**Recommendation:** Approve

**Applicant:** Mr D & Mrs A Brace

**Proposal:** Single storey extension and various internal alterations. New windows and rooflights

Job No: 19\_011\_ 107  
Drawing No: 107  
Revision: A

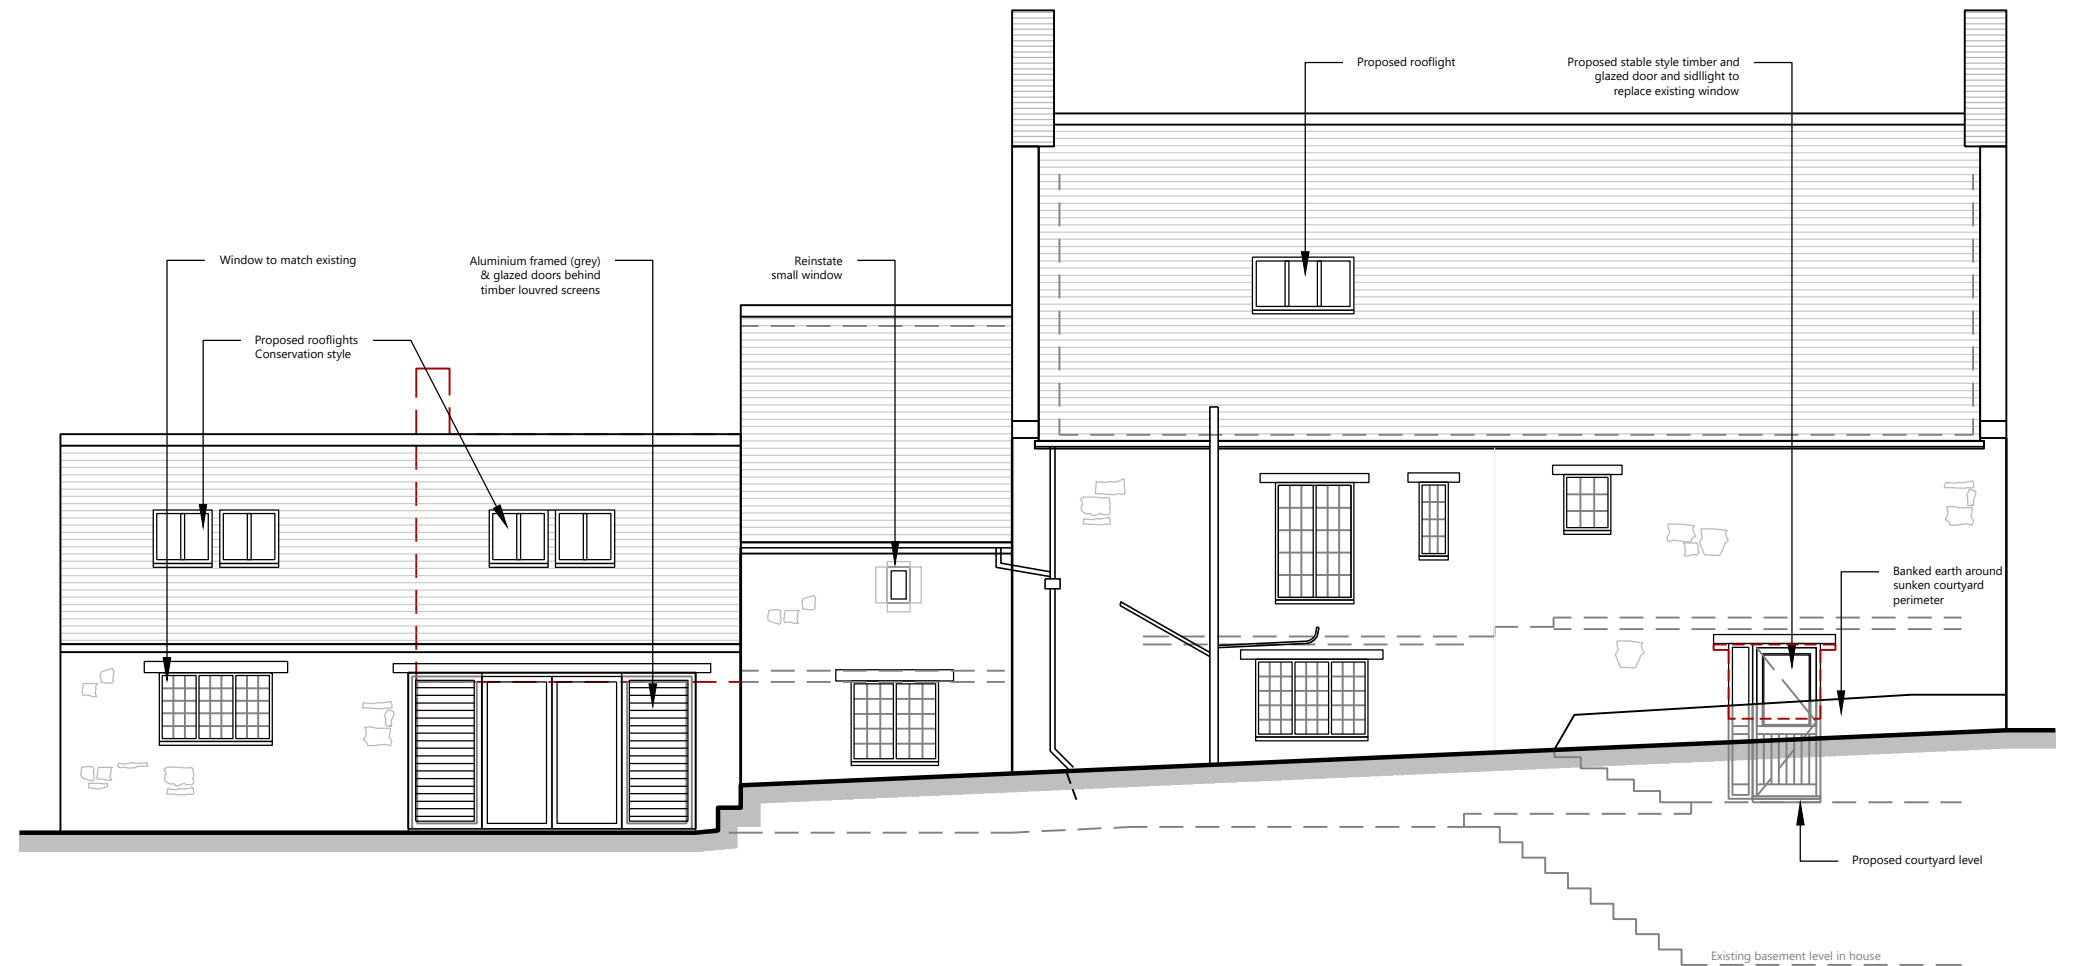
- 8.4. The number of rooflights in the extension has been reduced, with 2 to the rear of the extension and none to the front, and the design lent a more vertical design with the use of central glazing bars as suggested by Conservation.

- 8.10. The extension would be subservient in size and scale, with a ridge line considerably lower than that of the host dwelling to which it attaches, and with the front and rear elevations set back compared to the single storey extension it would attach to.
